ENG-SF21026-R3-CDs.pdf Markup Summary

RD09

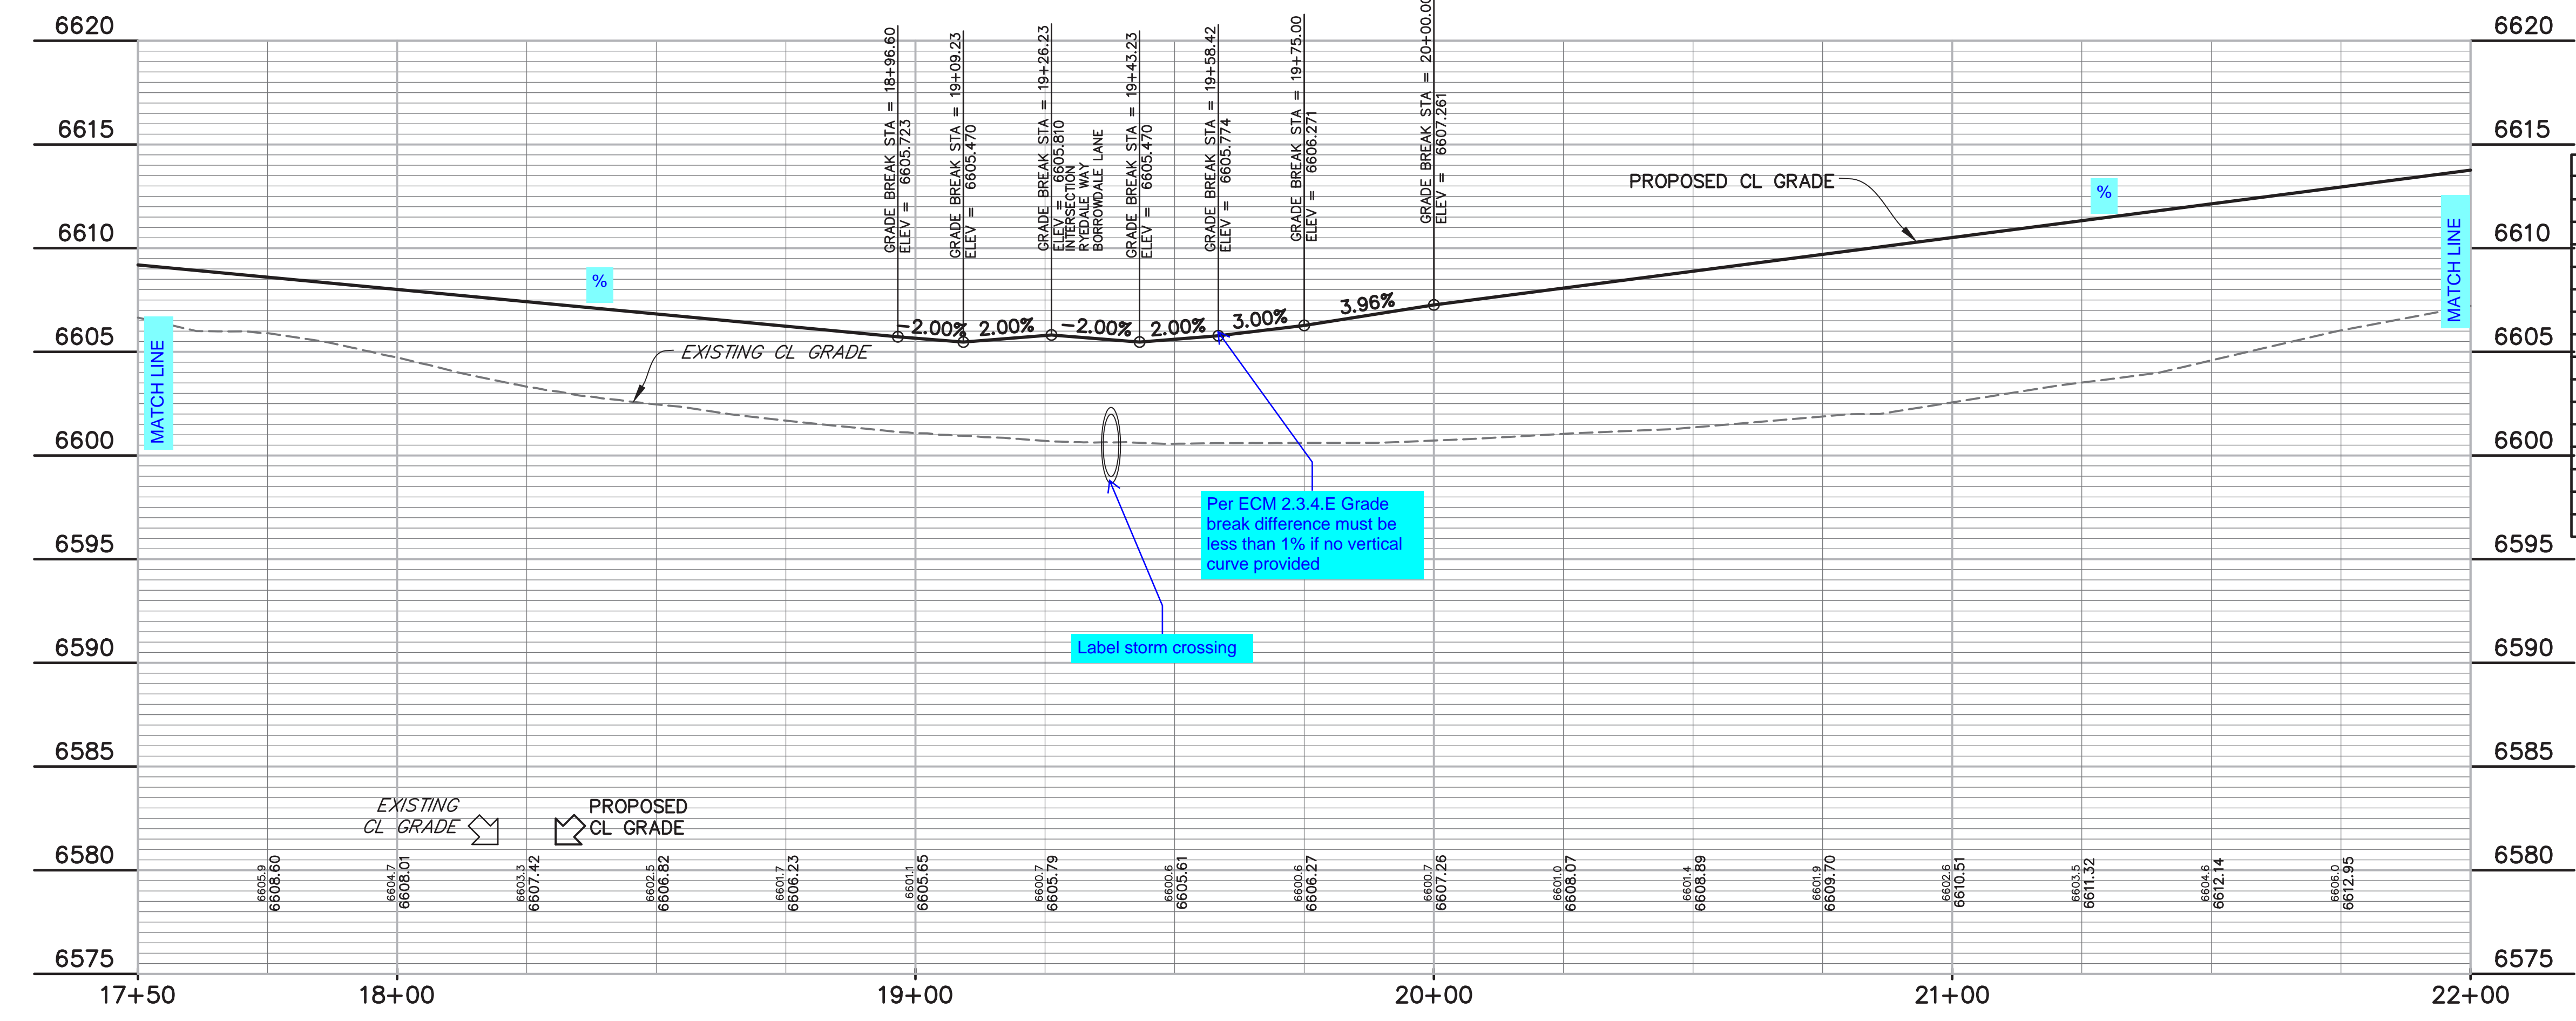
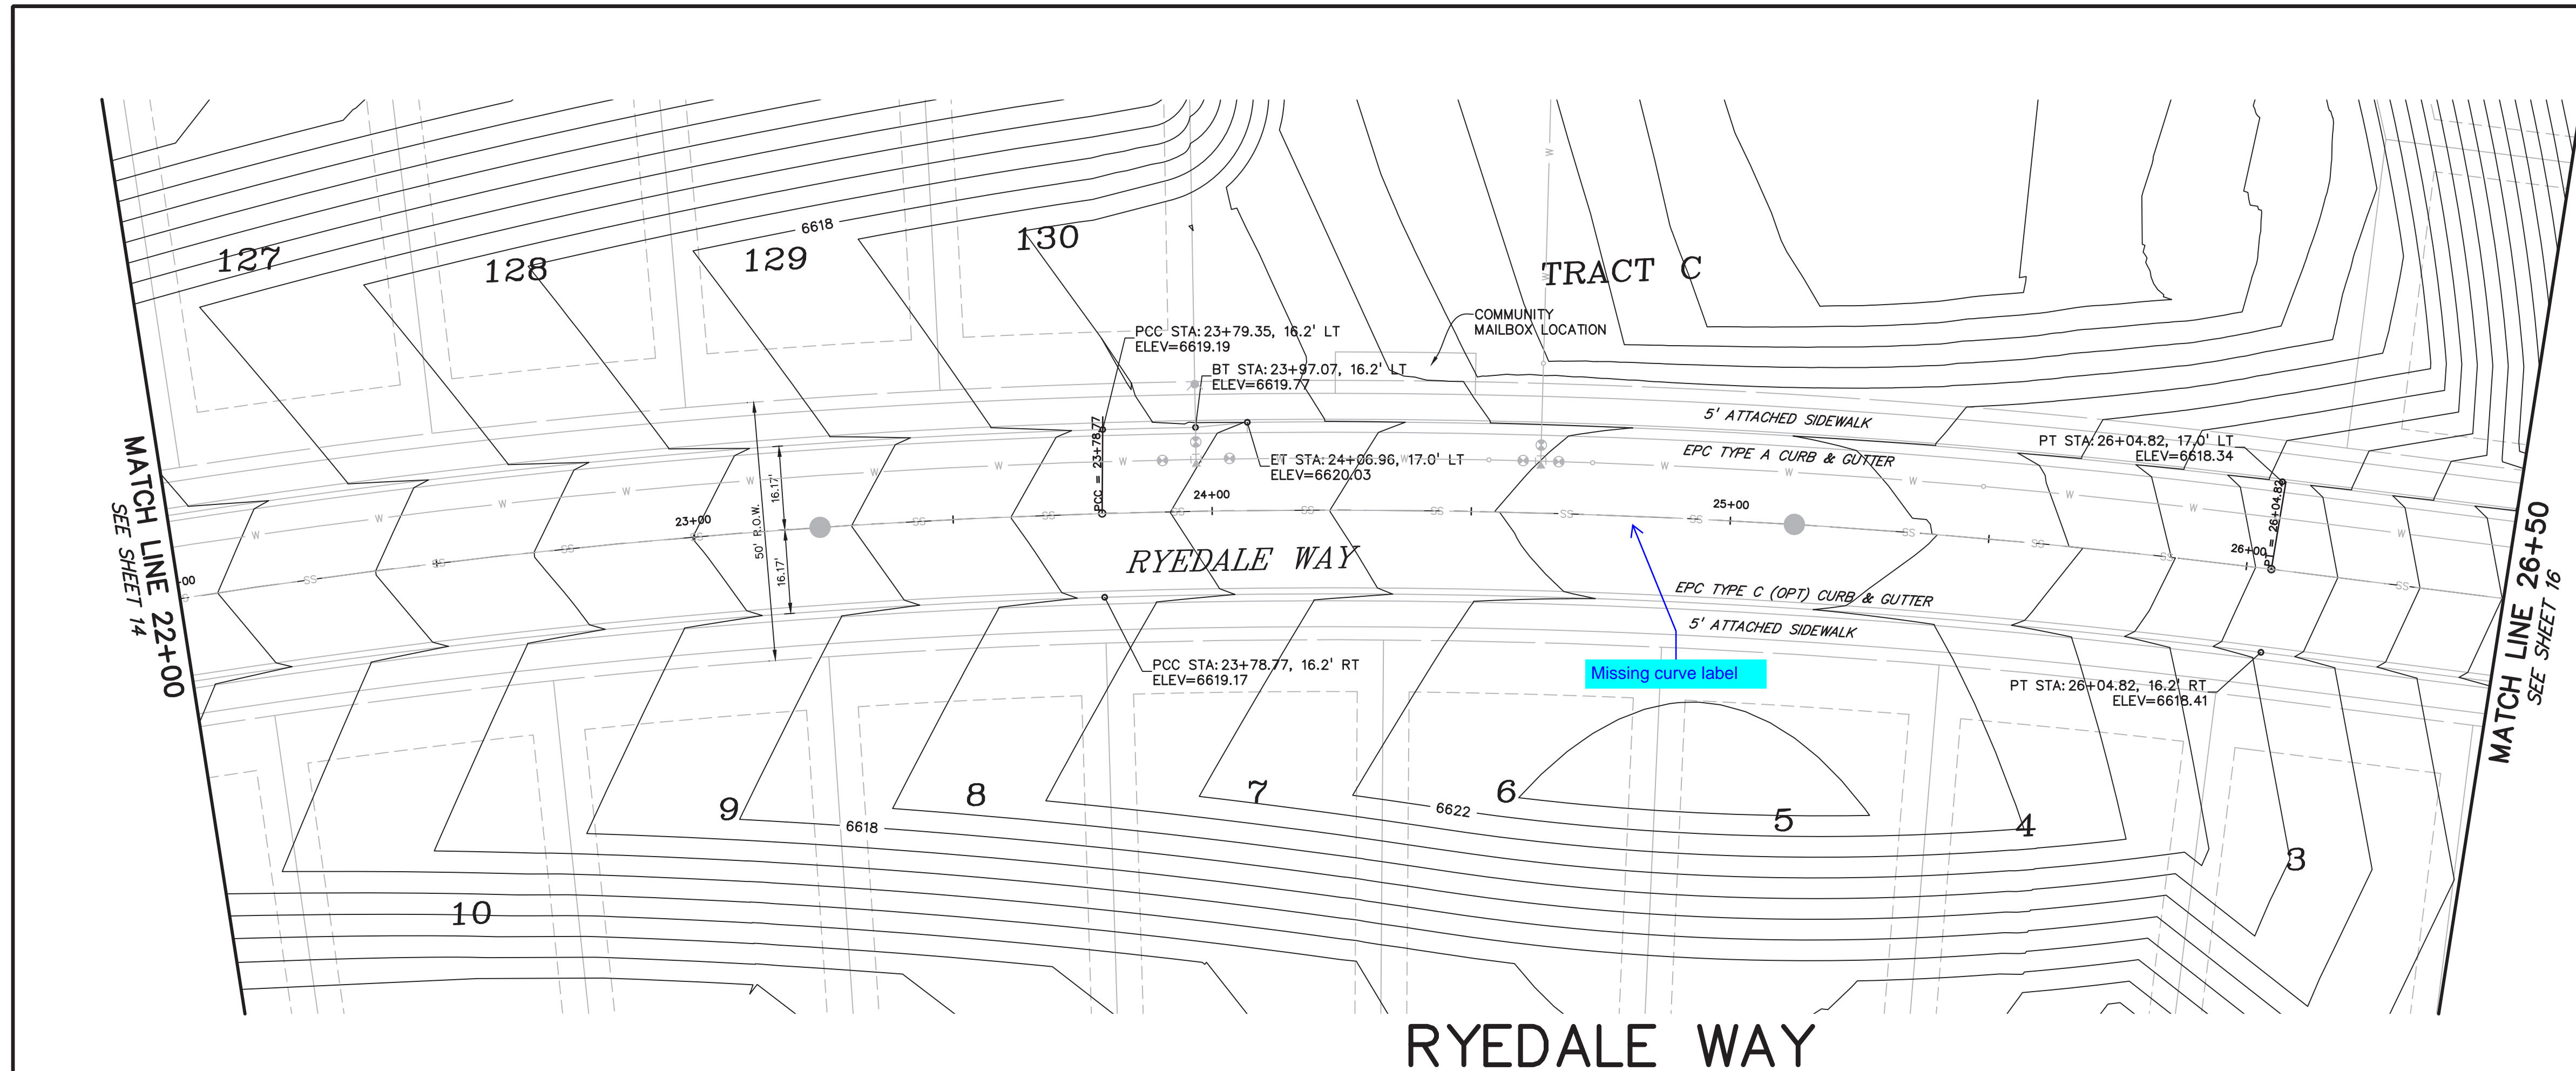
Per ECM 2.3.4.E Grade break difference must be less than 1% if no vertical curve provided

Show water and sanitary crossings in profile

Label storm crossing

RD10

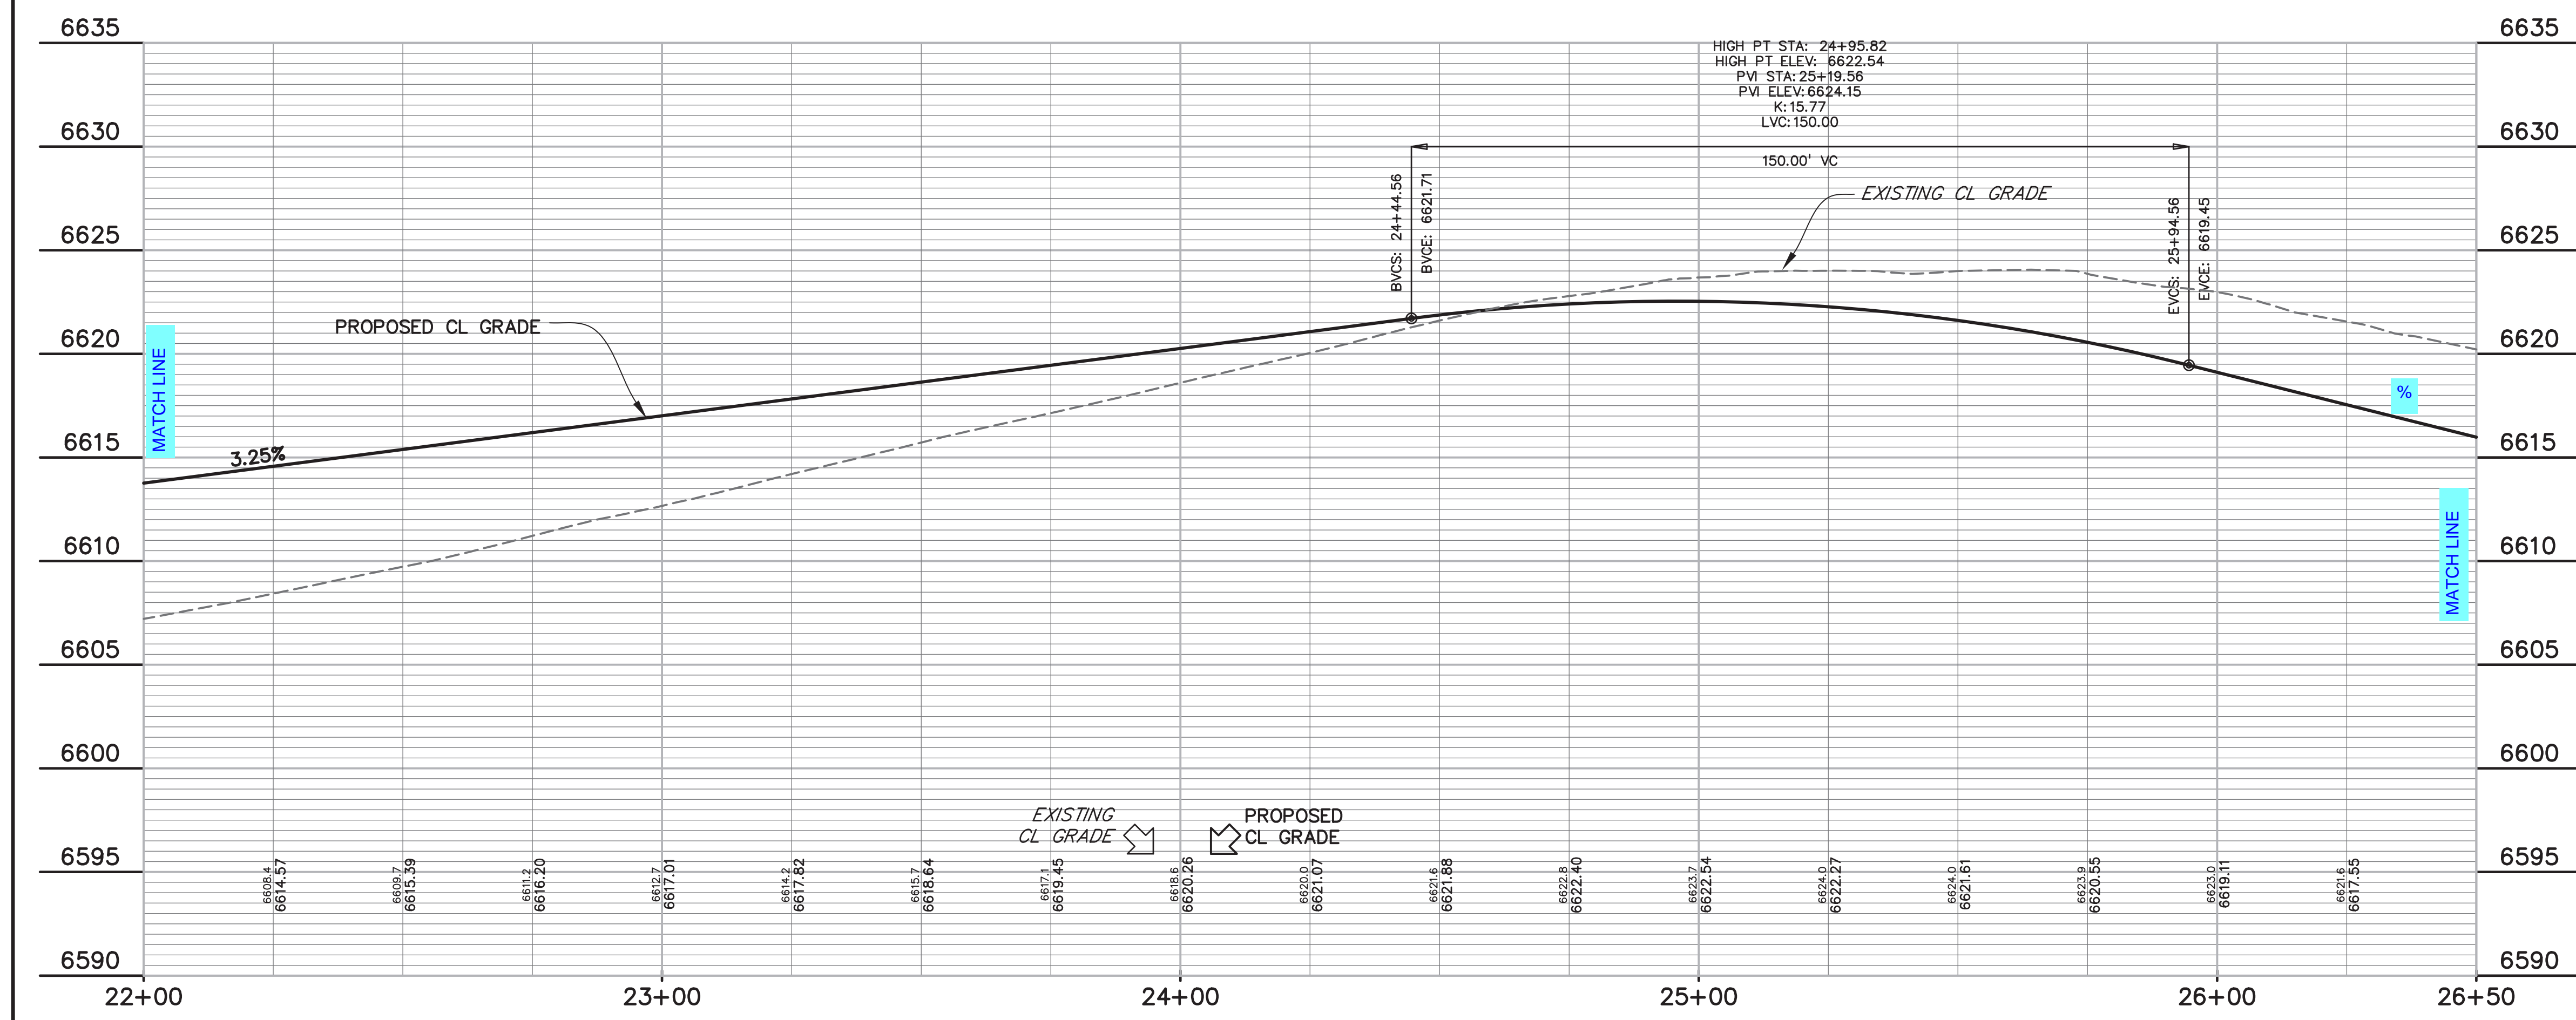
Missing curve label

RD13

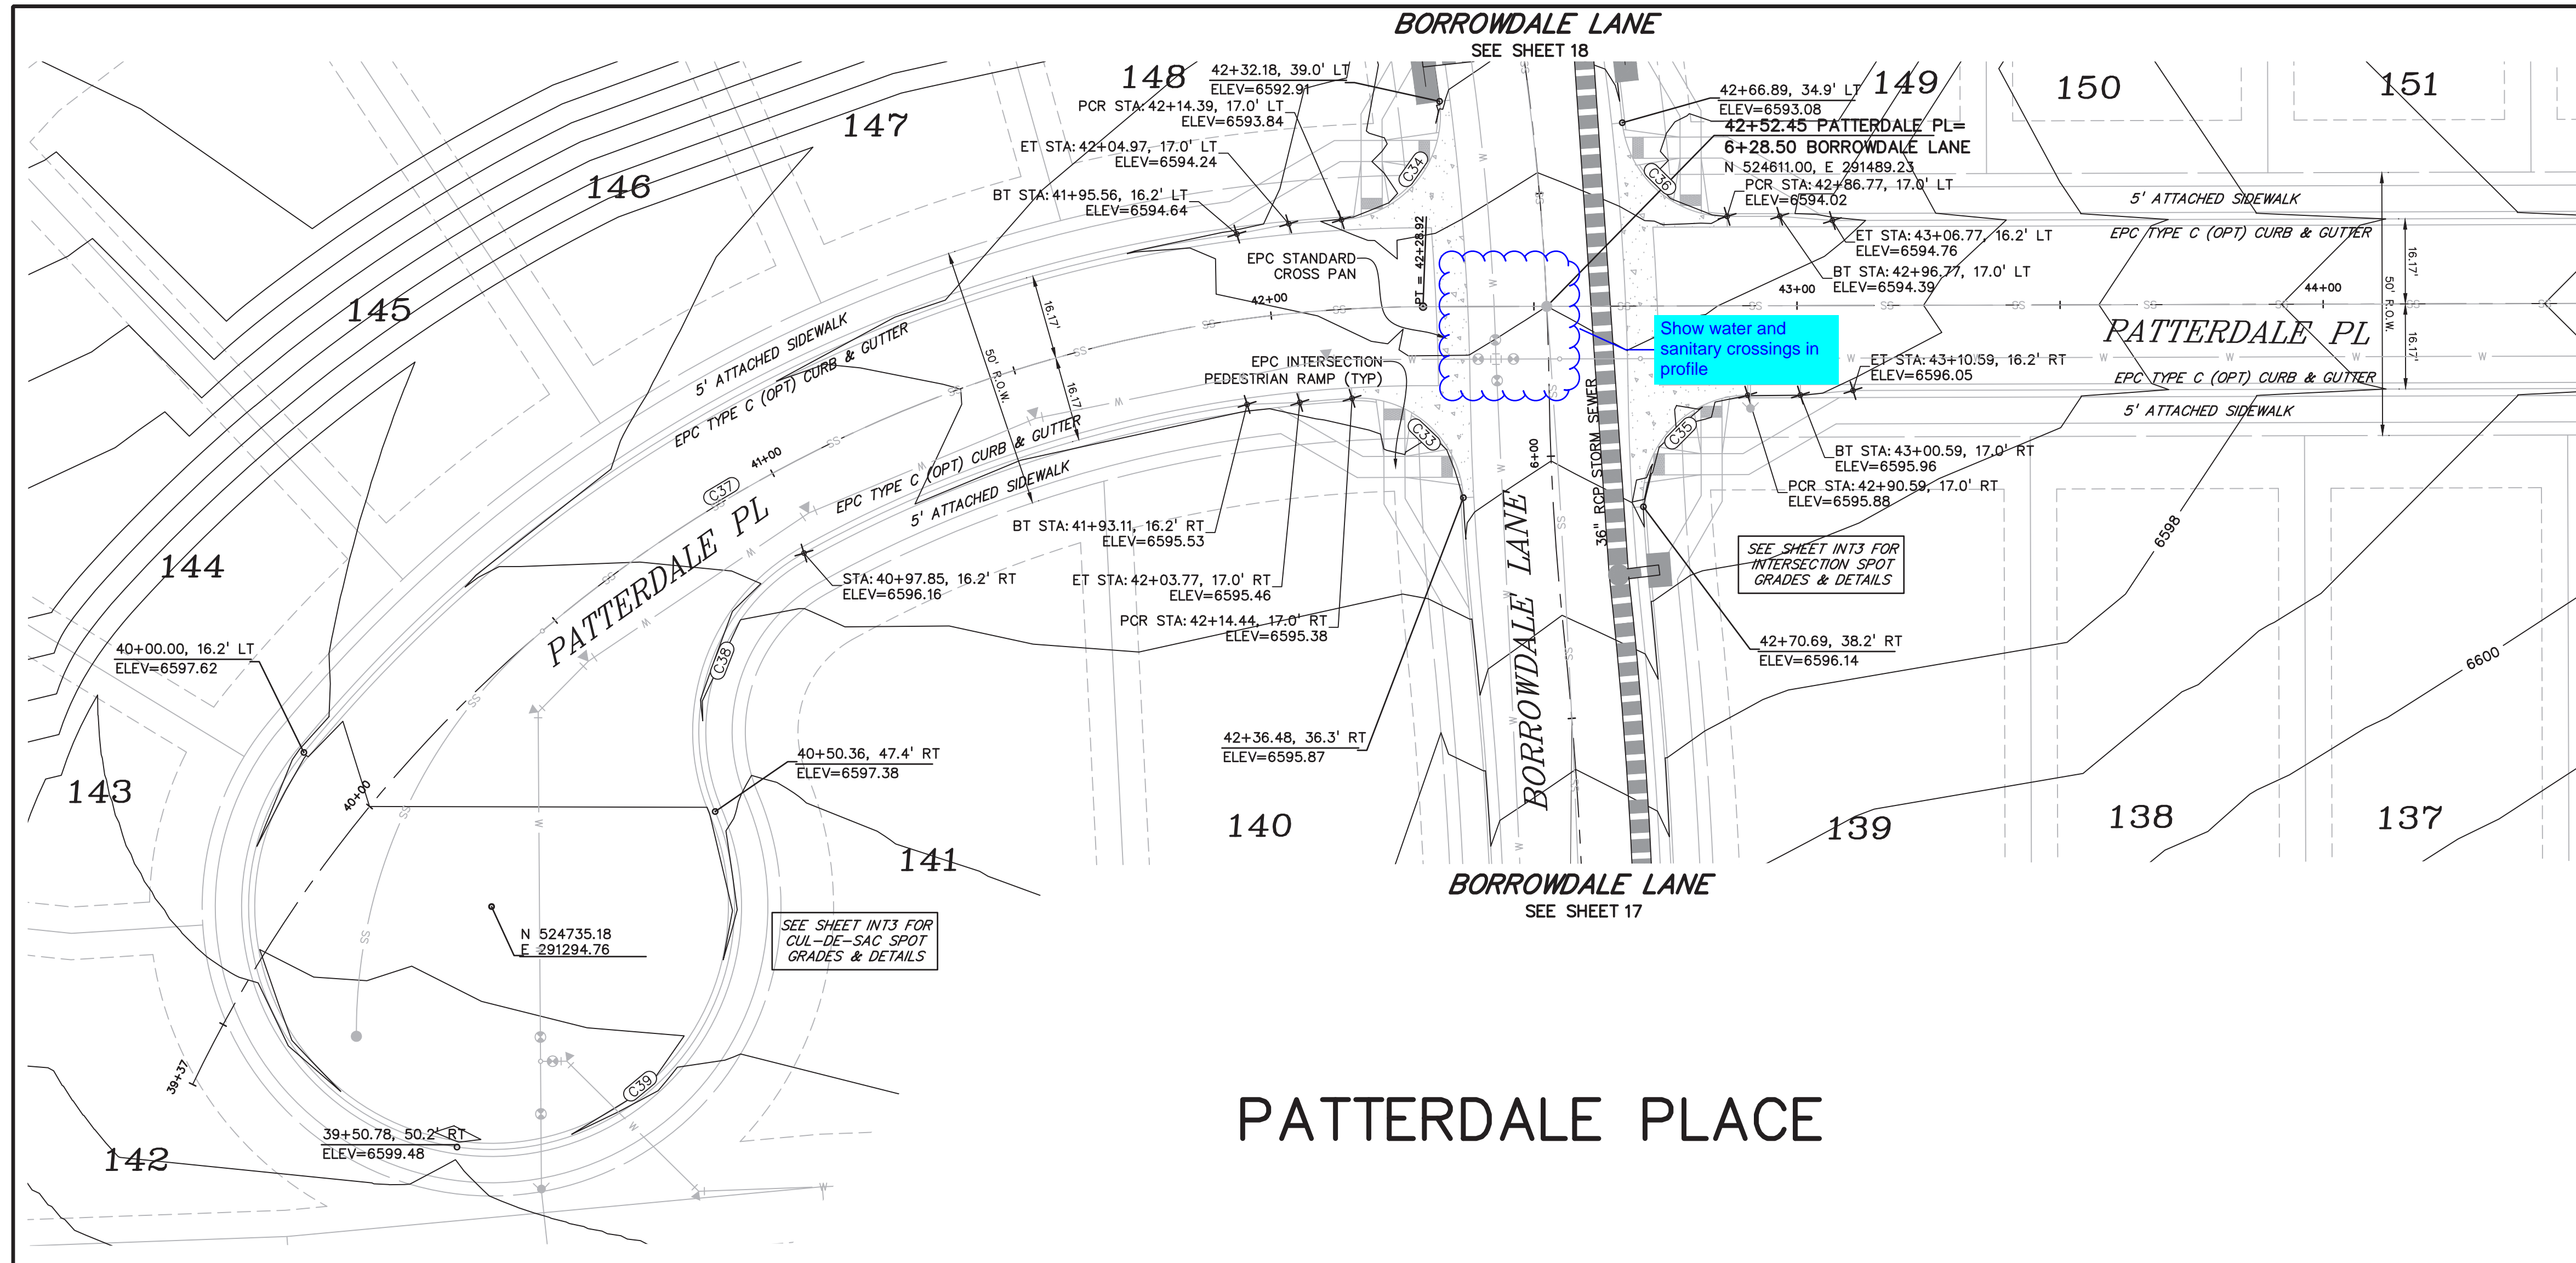
Min K-value for sag curve = 26

Fix overlapping text

Show water and sanitary crossings in profile

Show sanitary crossings in profile

Separate profile for laterals

What is this?
